Application Ref: 2025/65/91645/W - Turnbridge Mills, Quay Street, Huddersfield, HD1 6QT

**Proposal:** Listed Building Consent for redevelopment of site for mixed-use E(g) (i, ii and iii) and B8 including: demolition of buildings and re-cladding of southern elevation of retained adjoining building; retention, conversion and renovation of existing mill/office/workshop/engine house building including alterations; erection of two new buildings; formation of two vehicular access points, service yard and parking areas; and other associated works.

**Comments:** Thank you for notifying HB&P of the above application for listed building consent. HB&P object to the complete demolition of building B, the grade II listed Spinning Block at Turnbridge Mills.

Client	JLB Group		
Project	Condition Appraisal Turnbridge Mills Quay Street, Huddersfield		
Drawing	Building B Existing Plans		
Date	June 2014	Drawn	RL
		Checked	Scale
			1:500@A4
Drawing No.	1908-14-02		Revision
			-

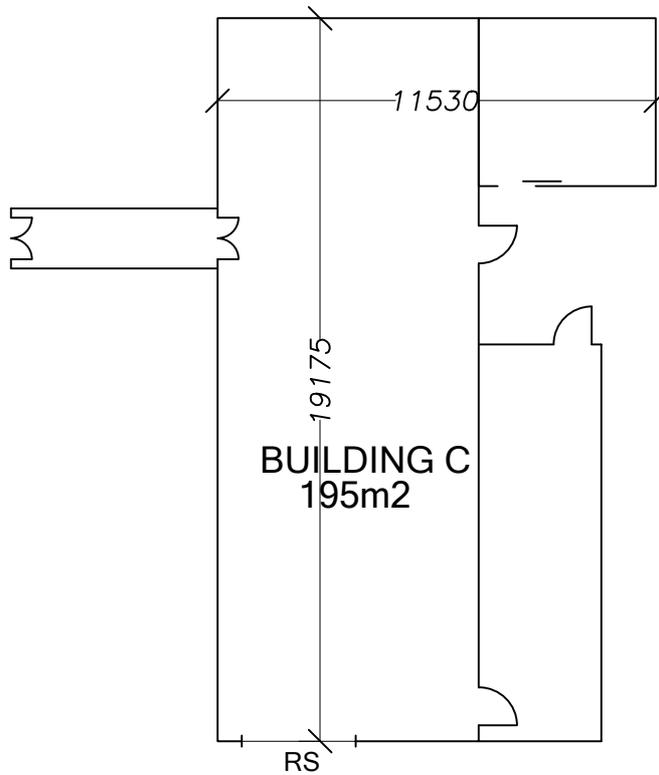
The structural assessment for Building B shows that the defects are not catastrophic and that it is capable of repair and therefore there is no justification on structural grounds at this stage for demolition. The 'do nothing' approach does increase the risk of escalating those defects in the building and the applicant is reminded that any deliberate neglect will make it more difficult to justify any future development of the site.

**Recommendation:** Withdrawal until appropriate justification and exploration of the options has been carried out. Otherwise, the application should be refused on heritage grounds.

*Canal Elevation as Proposed*

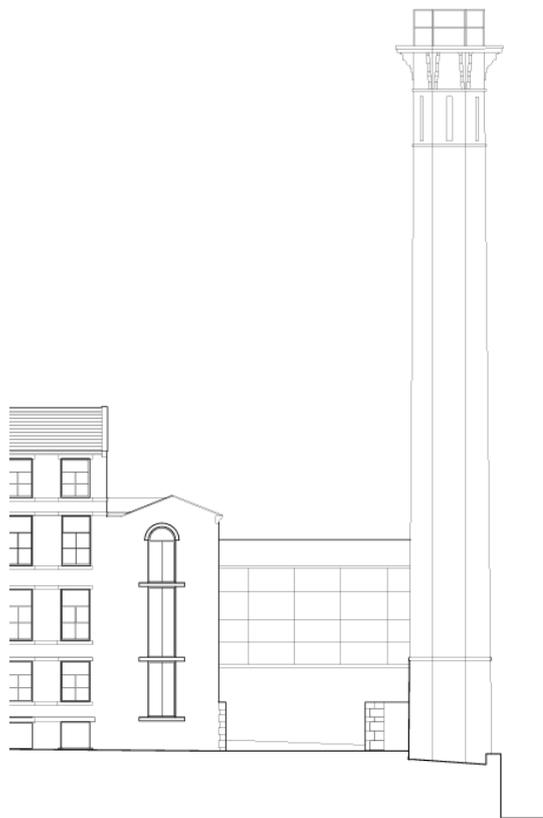
The recent listing of the mill building, despite no longer operating in that use, provides a clear indication of its ongoing historic interest as both a standalone building and for its group value with the other listed and curtilage listed buildings that made up the wider mill site. The complete loss of a heritage asset represents substantial harm. Demolition of a listed building should only be permitted as a last resort and in exceptional circumstances, and HB&P do not believe that the test in the NPPF (2024) at Para 214 has been satisfactorily addressed.
